TO: All Staff  
FROM: Public Works Plan Review Team  
DATE: December 2, 2021  
SUBJECT: BL-21-00027 Harms

The Public Works Department has reviewed the Request for Boundary Line Adjustment Application.

### BOUNDARY LINE ADJUSTMENT BL-21-00027

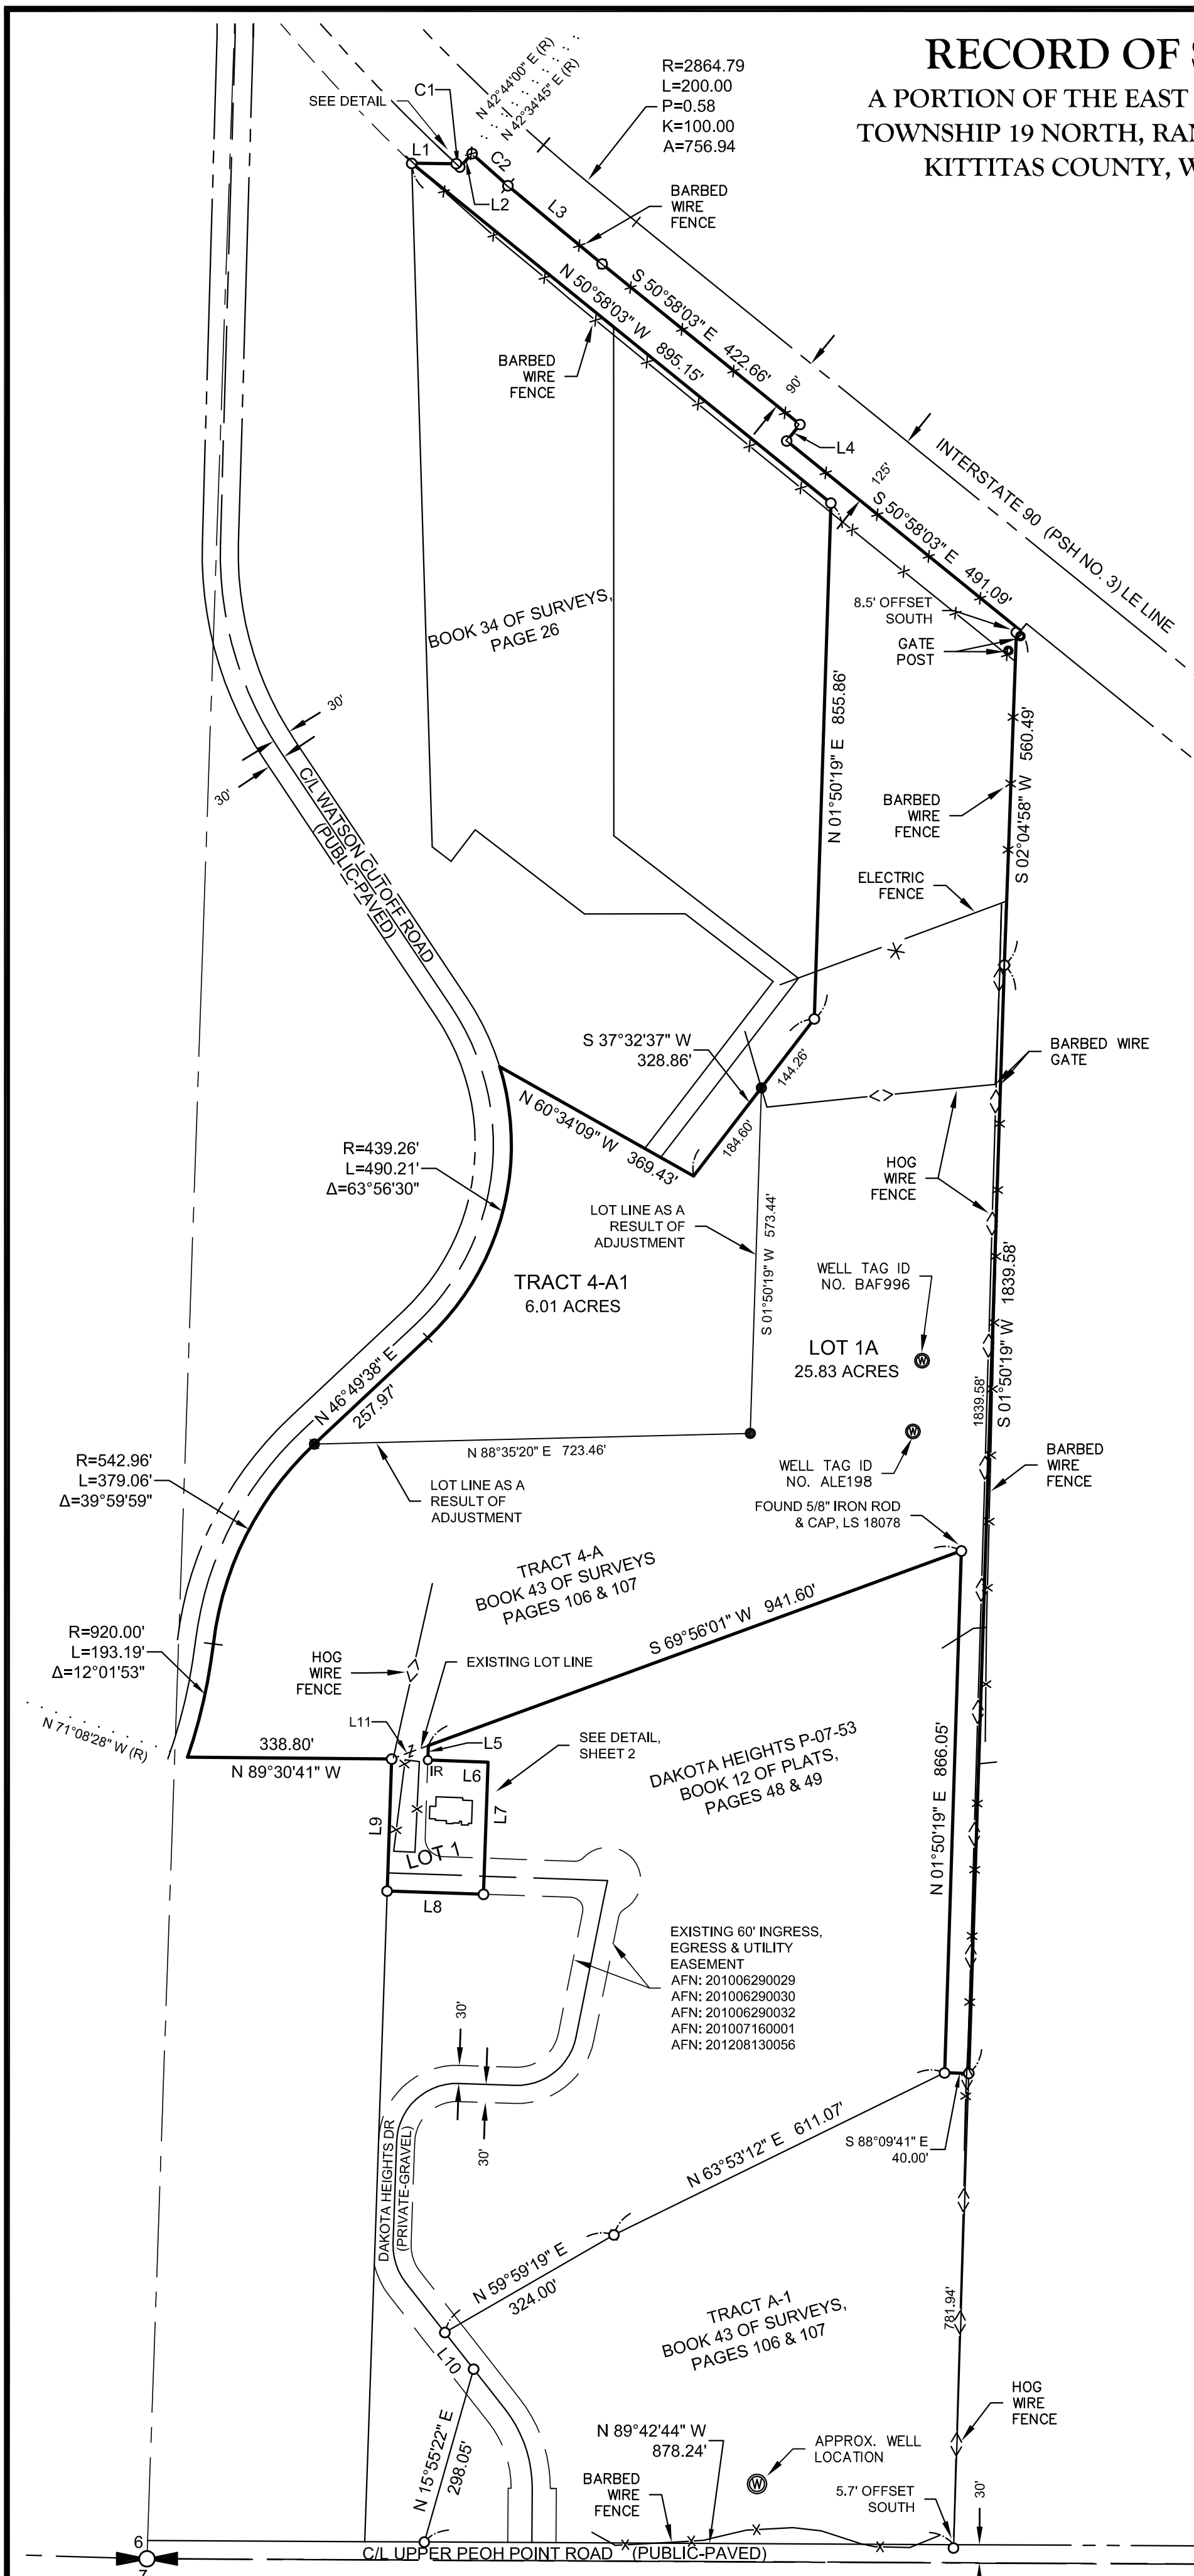
1. Township Section and Range to be shown in Large print at top of page.
2. The following statements must be included:
  - Survey equipment and Procedures
  - Purpose of survey
  - Surveyors Certification
  - Auditors Certification

3. Please include ownership and surfacing for the county roads (Watson Cutoff and Upper Peoh Pt Rd.
4. Please label Dakota Hts Drv. And include ownership and surfacing (private- gravel).
